Arboricultural Comments (TCA & TPO):

Date: 07/03/2016
Case Officer: Caroline Morrey
Target Date: 08/03/2016
CDC Reference: 16/00029/TCA
Site Address: Cedar Court
Water Lane
Steeple Aston
Bicester
OX25 4SB

Trees / Proposal (brief description): T14 x Sycamore – Fell
T25 x Beech – Crown raise up to 10%, prune few smaller branches low on the trunk.

CEDAR COURT, WATER LANE, STEEPLE ASTON, OXON, OX25 4SB
 (OUTLINE PLAN OF HOUSE/GARDEN AND TREES - NOT TO SCALE)

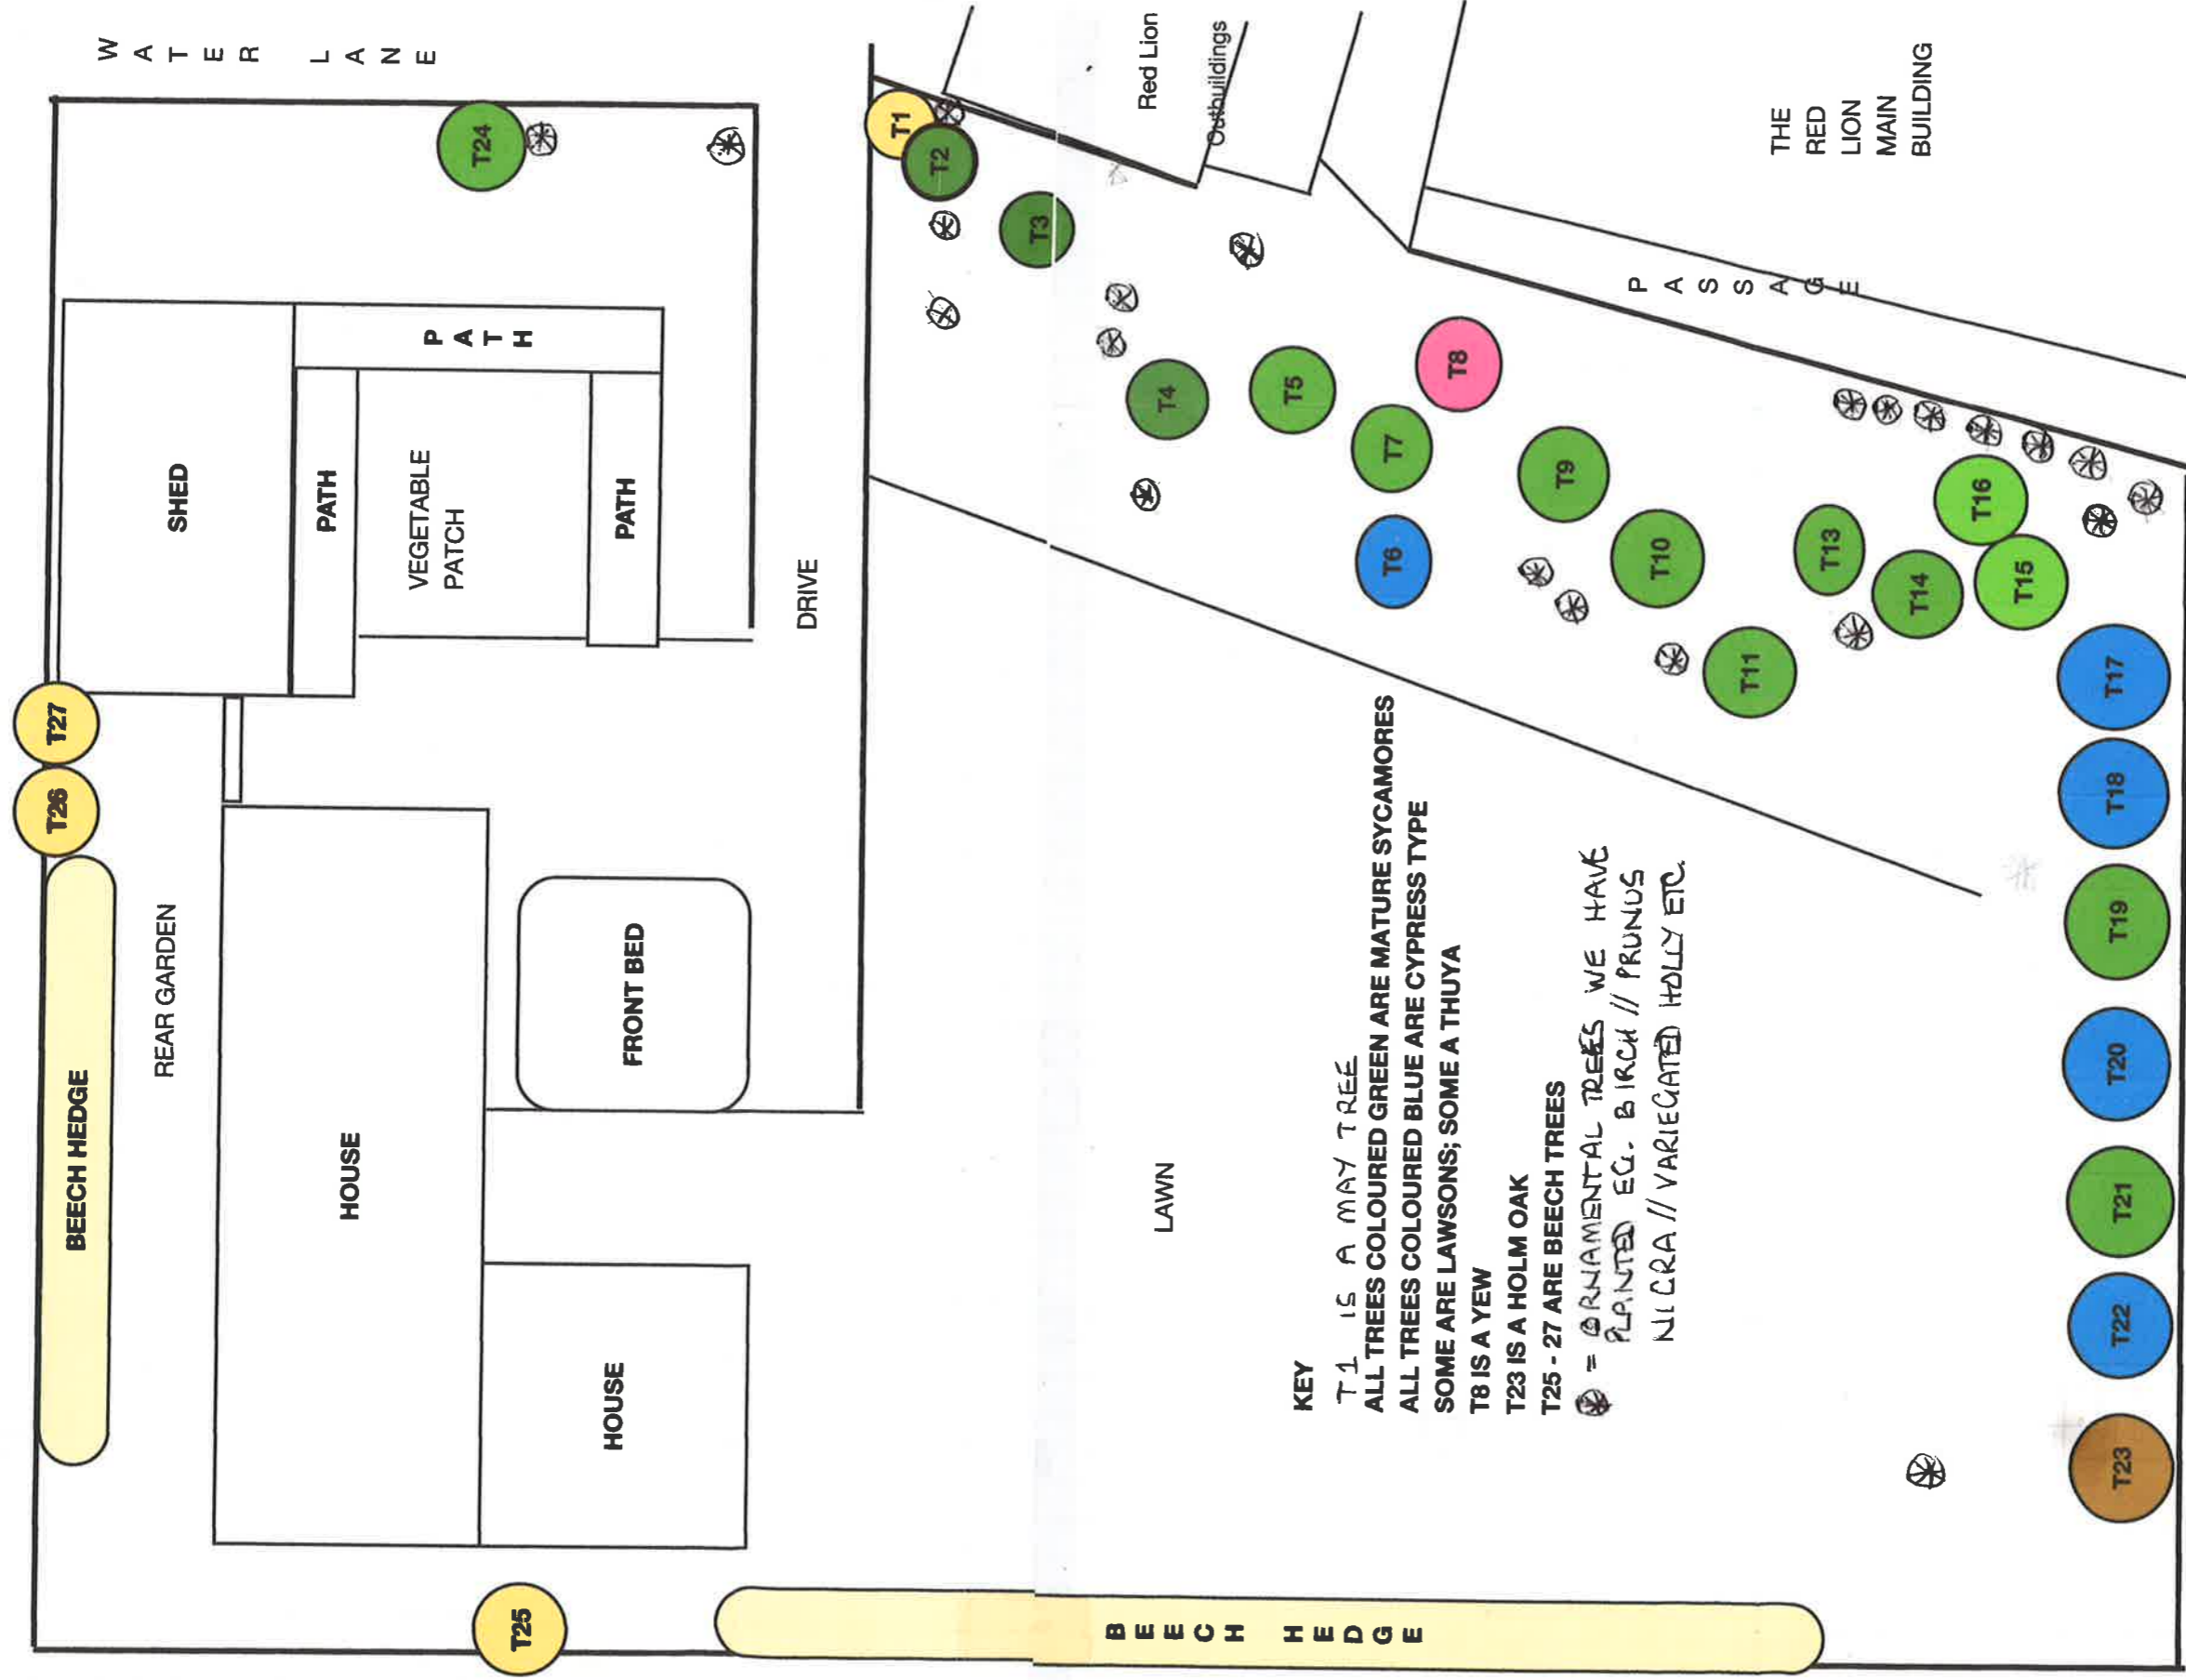
Significant comments: The sycamore tree is of limited public amenity value. The work proposed to the beech tree is minimal and should not have a significant impact on the health of the tree.

Conclusion: No arboricultural objections to the proposed works.
